## Technical Note

Project No: ITB13091  
Project Title: Ford Airfield – The Landings  
Title: Sustainable Accessibility Addendum Note  
Ref: 13091-029  
Date: 5 August 2020

- 1.1 Planning application F/4/20/OUT has been submitted to Arun District Council for consent for development of up to 1,500 dwellings, 60-bed care home, up to 9,000sq of employment floorspace, local centre of up to 900sqm of retail commercial and 1,450sqm of community/leisure floorspace, land for a two-form entry primary school, public open space, allotments, new sports pitches and associated facilities, drainage, parking and associated access, infrastructure, landscape, ancillary and site preparation works, including the demolition of existing buildings and part removal of existing runway hardstanding.

B	29.10.20	JD	RSA COMMENTS INCORP'D	DS	DS
A	16.07.20	JD	FOOTWAYS AMENDED	DS	DS
REV	DATE	BY	DESCRIPTION	CHK	APD
STATUS: DRAFT					
SCALE @ A3: 1:500		CHECKED: DS		APPROVED: DS	
FILE REF: ITB13091		DRAWN: SH		DATE: 17.07.18	
DRAWING No: ITB13091-GA-006					
PROJECT No: ITB13091				REV: B

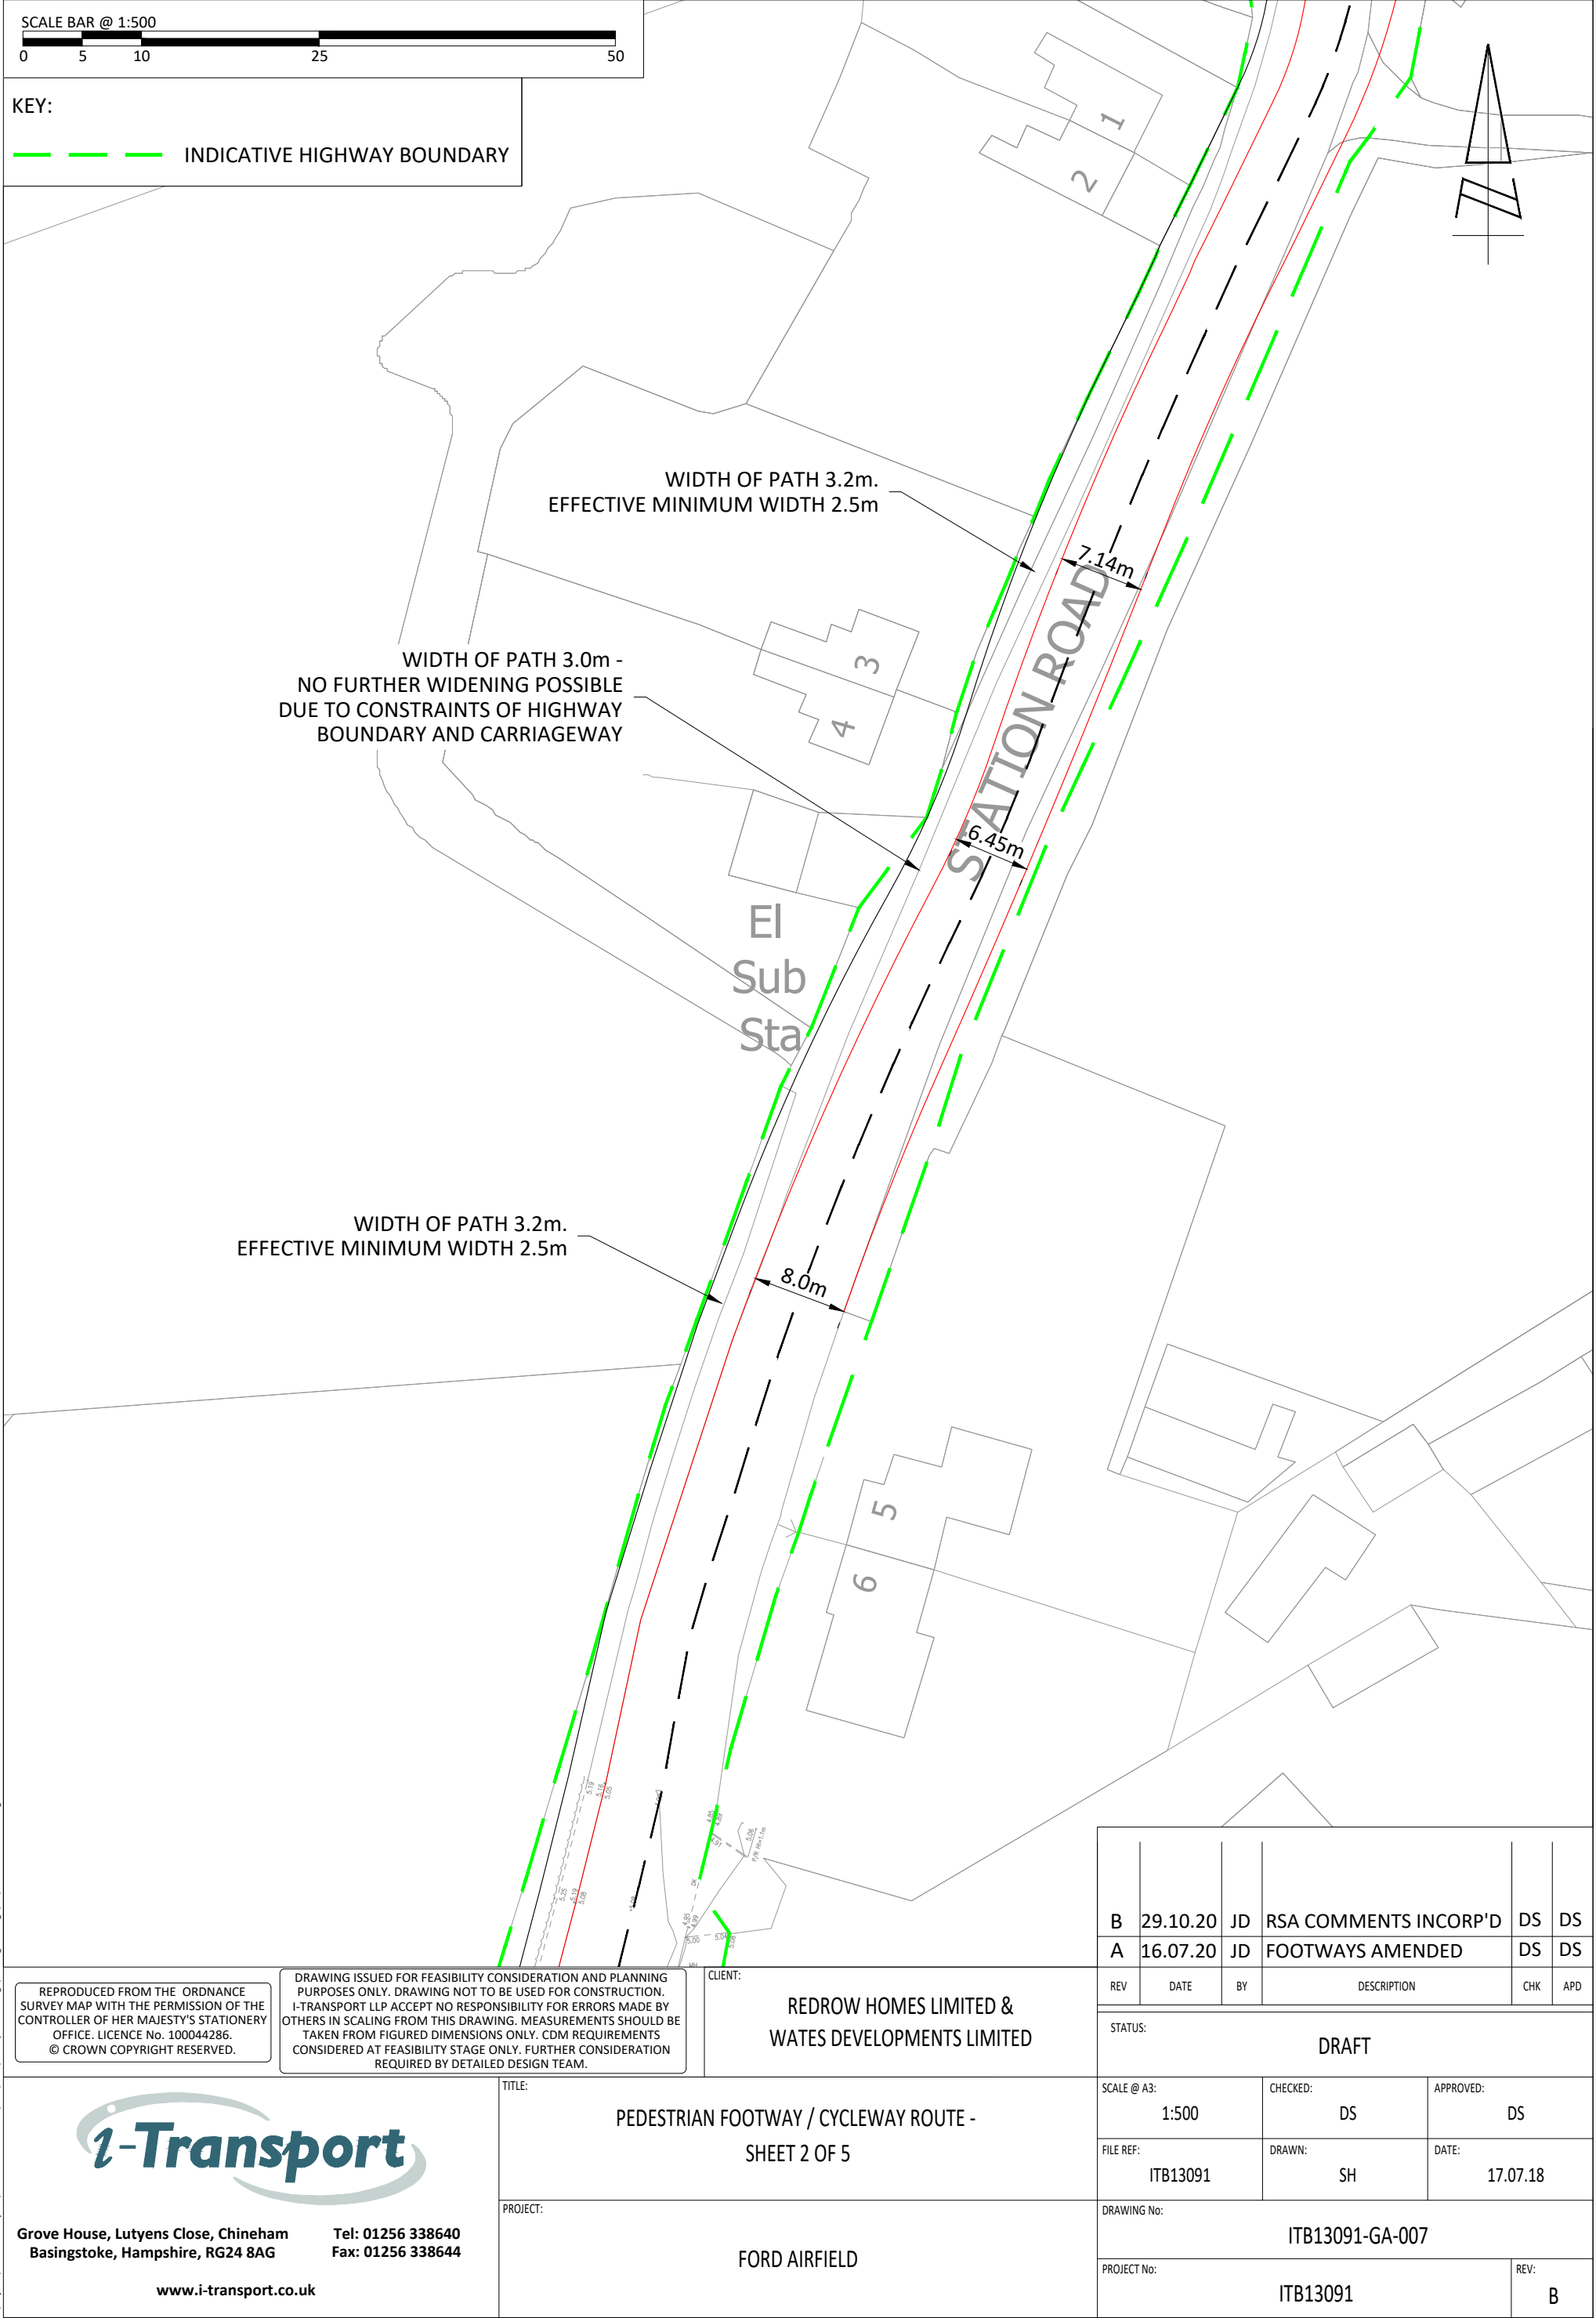
- 3.6.3 Notwithstanding, the scheme of works identified within the original assessment has been reviewed in the context of the CDG. Given the need to retrofit an improvement scheme within the constraints of the existing highway, it is not possible to provide a route that is fully compliant with the guidance. As identified in the guidance, where it is not possible to do this then the provision should be considered on a site-specific basis.

- 3.6.4 The identified scheme of improvements has been reviewed to allow for additional widening where possible. At locations where the route does not have a vertical obstruction on the eastern side of the highway boundary, an effective minimum width of 3.0m has been achieved by providing for an additional 200mm widening, achieved by offsetting the carriageway to the east of its existing alignment, or narrowing the carriage marginally (while maintaining a road width of a minimum of 6.8m). Where a vertical obstruction is present (e.g. a boundary wall or vegetation) the effective width reduces to 2.5m.

- 3.6.5 The revised scheme of improvements is presented in Drawings **ITB13091-GA-006 Rev A – ITB13091-GA-010 Rev A**.
